**Consultation Response from KC,
Lead Local Flood Authority**

2025/92187 Frankie And Bennys, Centre 27 Business Park, Bankwood Way, Birstall, Batley, WF17 9TB

**Date Responded: 11/09/2025.
Responding Officer: Martin Stephenson
Responding Ref:1**

DRAWING NUMBER
16209-2003

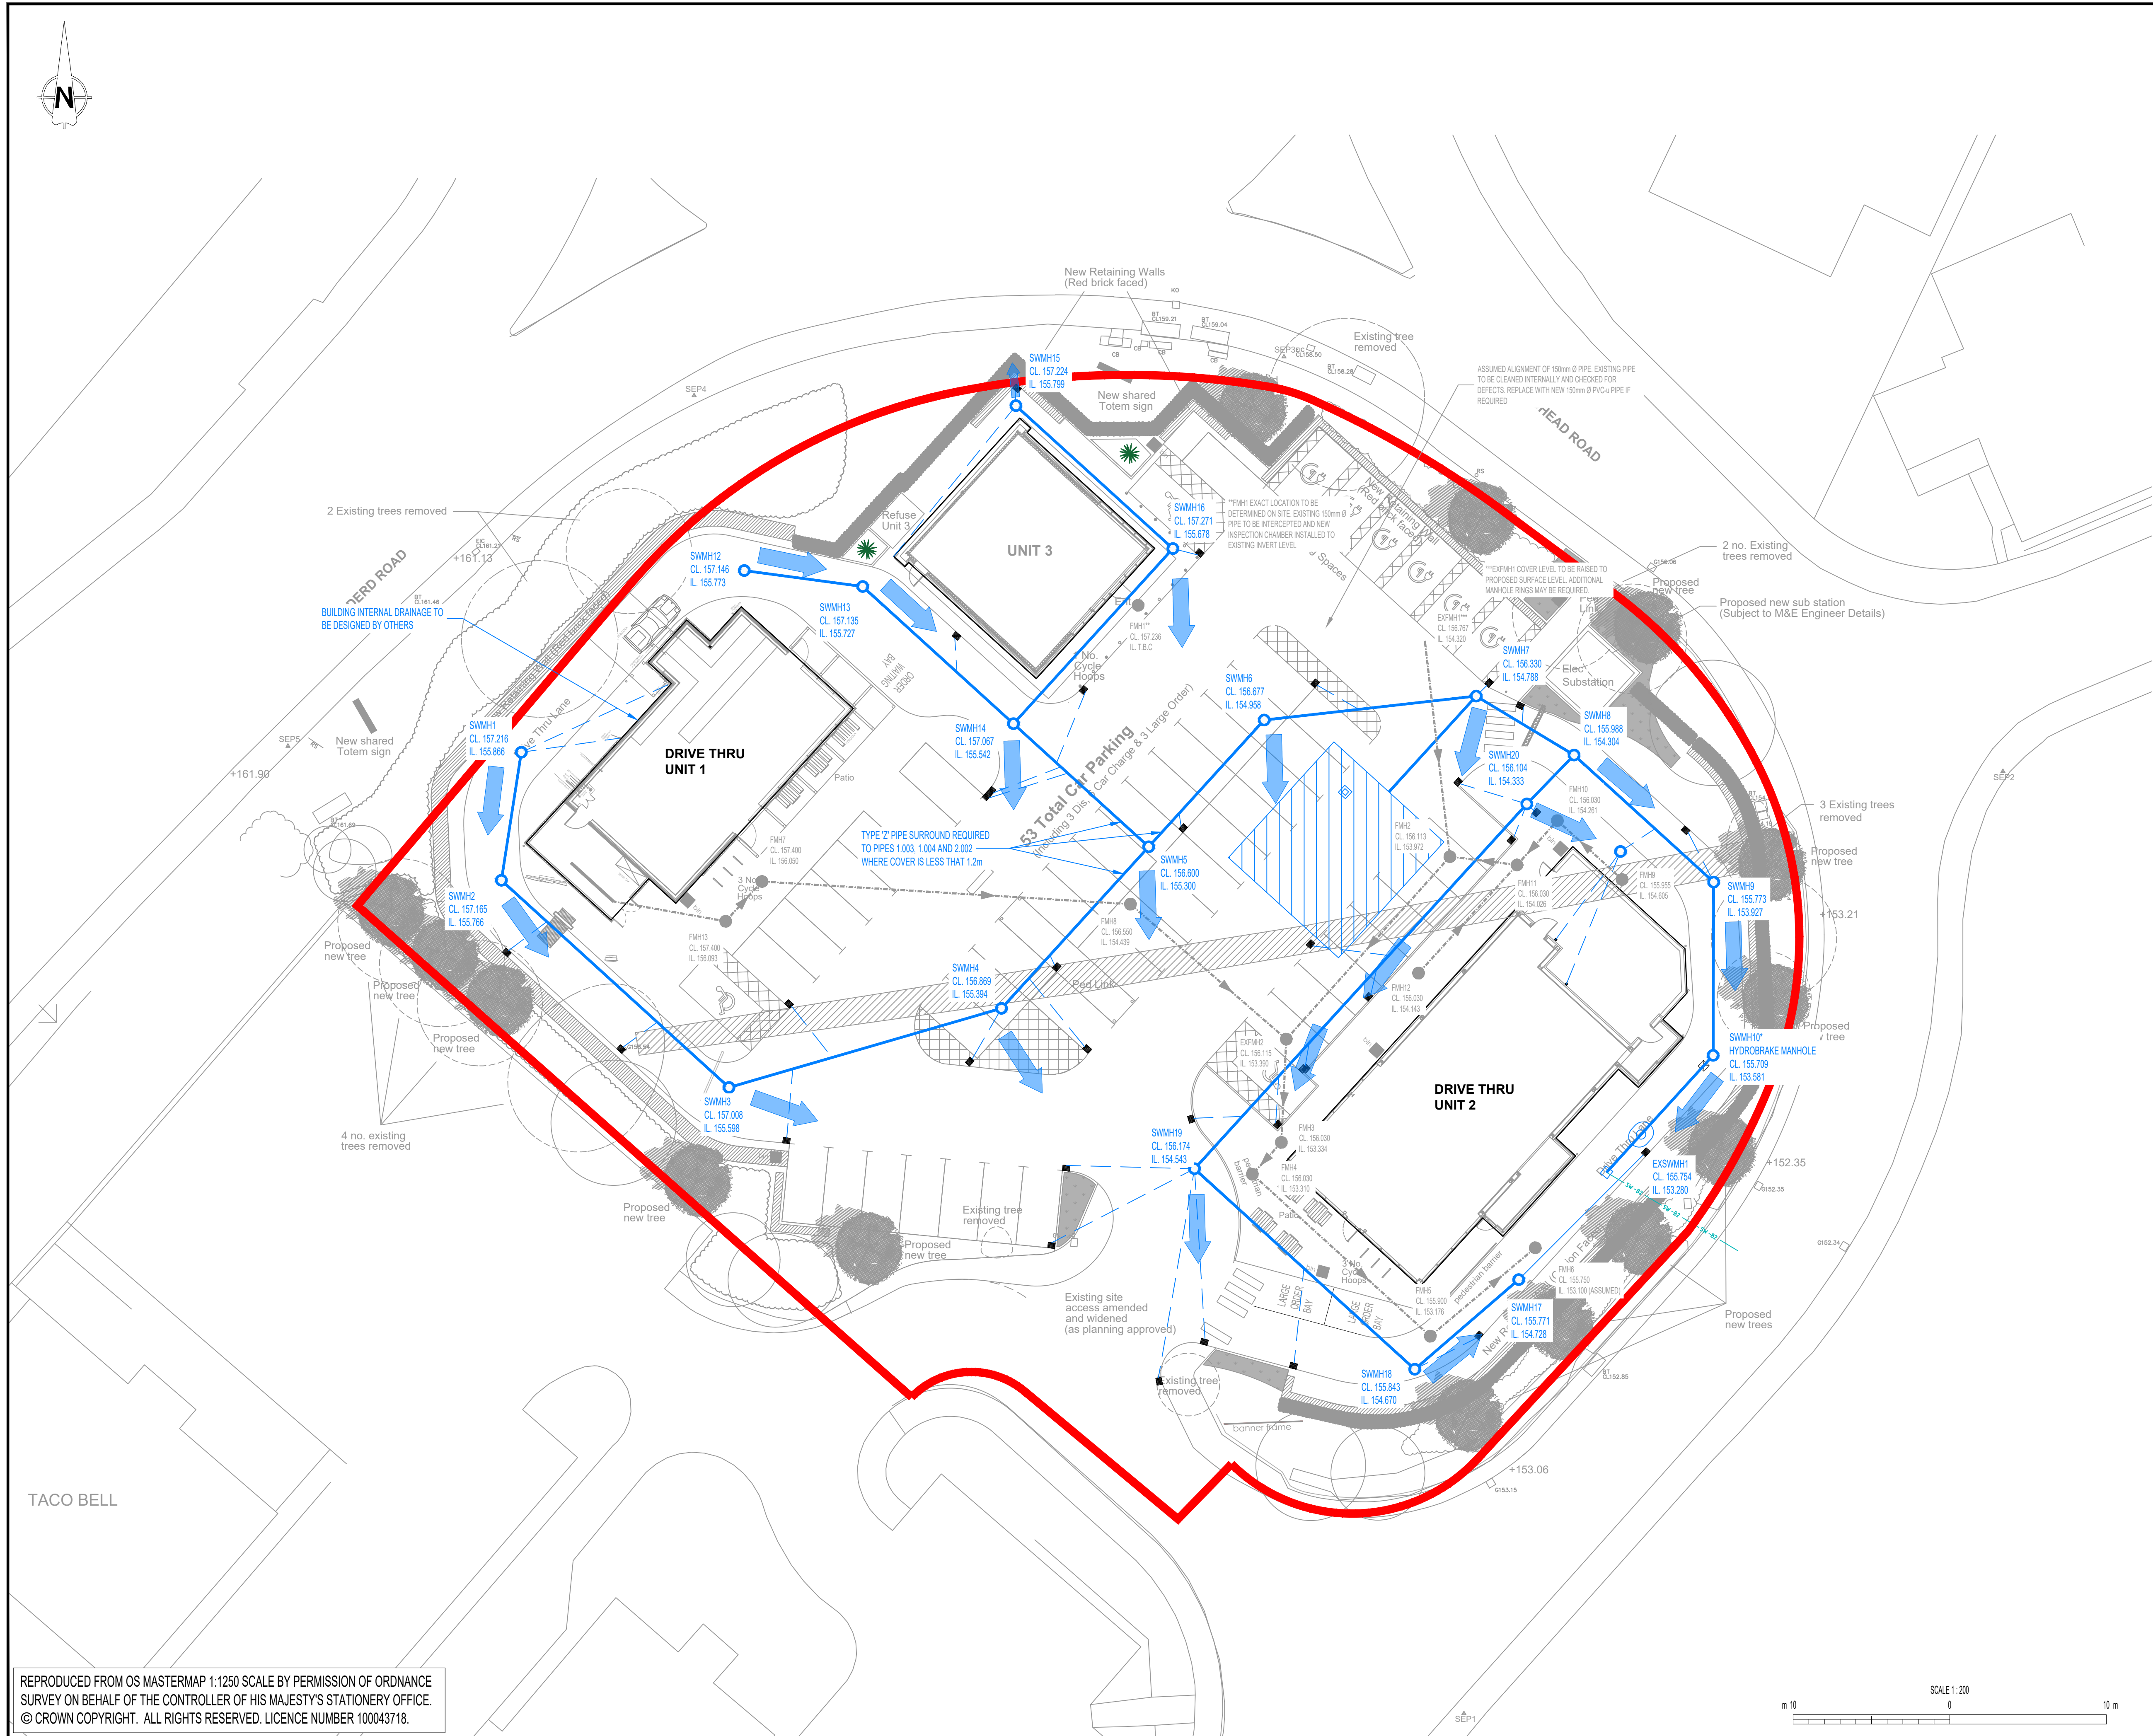
The submitted flood exceedance routing drawing is accepted by the LLFA; therefore Condition 9 can be discharged.
